From: [John McNally](#)
To: [Pamela Morales](#)
Cc: [Clare Harley](#); [Josh Ford](#); [Pulak Saha](#); [Meg Dsouza](#)
Subject: Orica Southlands SSD 9691 - Mod 1
Date: Wednesday, 9 March 2022 9:47:47 AM
Attachments: [image001.png](#)
[image002.png](#)

Thank you for notifying Council of the proposed modification of SSD 9691 at Orica Southlands. We have the following comments to make:

Impact on the Flood Retention Basin

DRIVEN PILES - OVERALL PILE PLAN
1 : 300

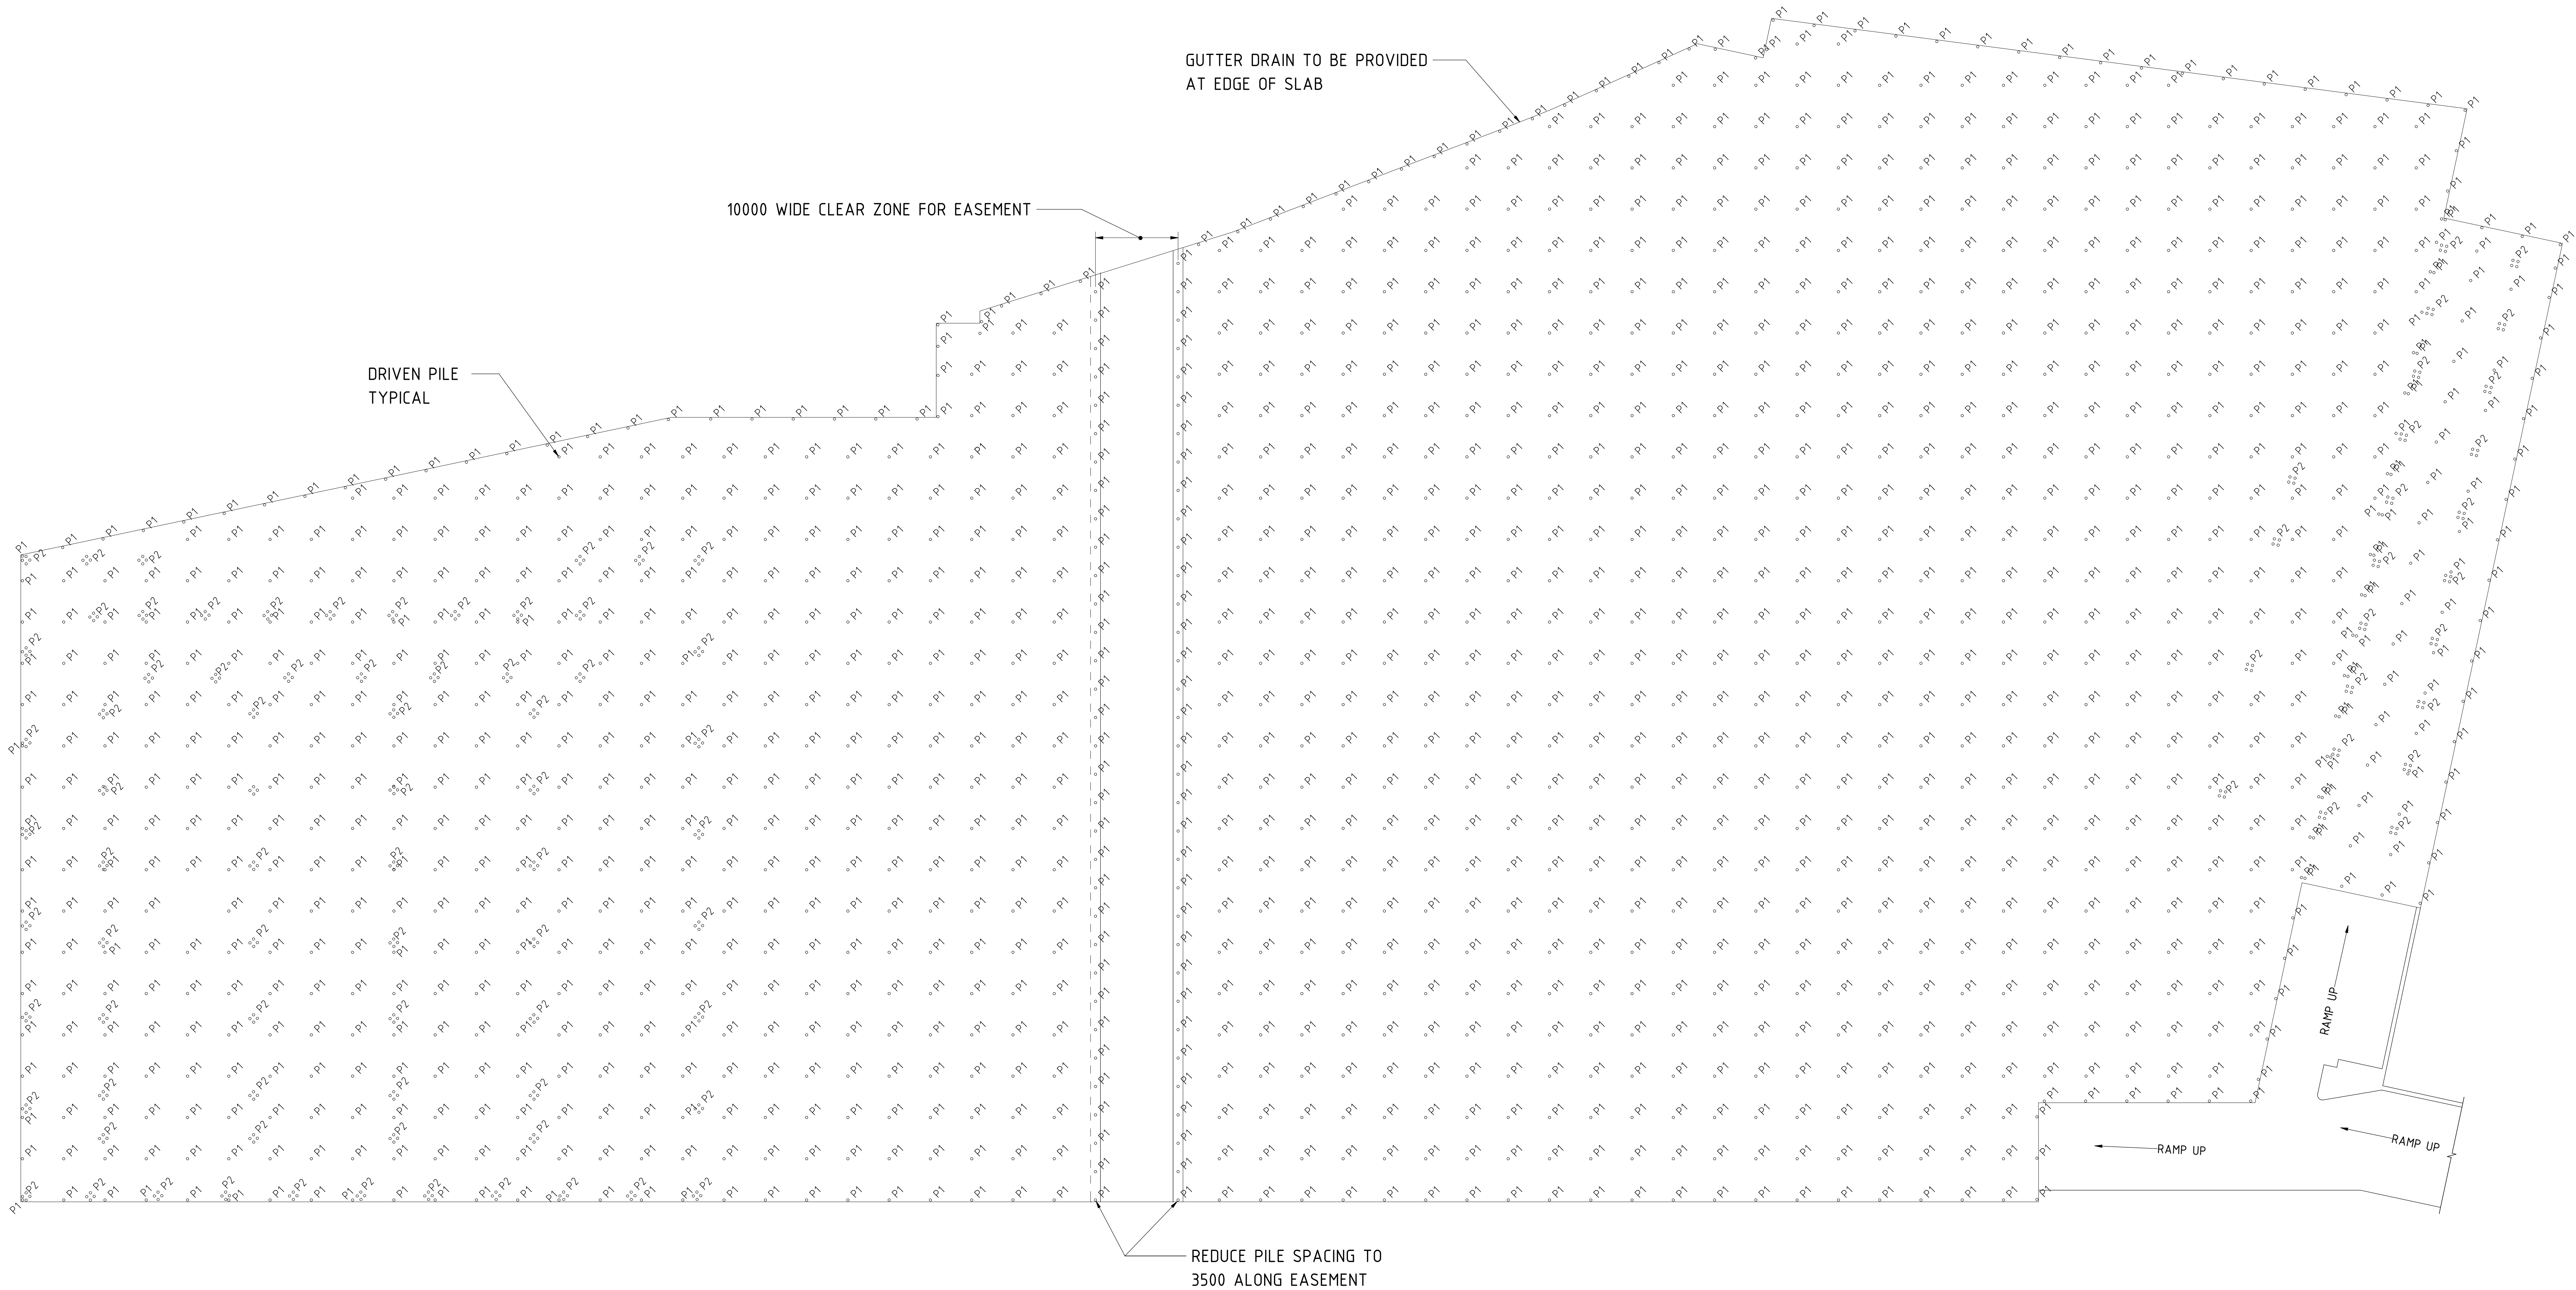
- The Flood Storage Assessment memo provided by Turnbull Engineering contradicts with the Environmental Impact assessment. EIA states that the diameter of the piles will be reduced to 400mm from original 800mm diameter. However, Turnbull Engineering calculated storage based on the 800mm diameter and as built survey;

- The EIA also indicates that a 10m wide corridor is proposed to allow maintenance of the flood storage basin underneath the warehouse podium. However, the preliminary structural plan confirms that the gap between piles will be reduced to 3.5 along the easement. The applicant needs to confirm whether a 3.5m gap will be sufficient to accommodate the maintenance vehicle for the whole area. A swept path analysis may be required to demonstrate that a maintenance vehicle can move freely around the basin;
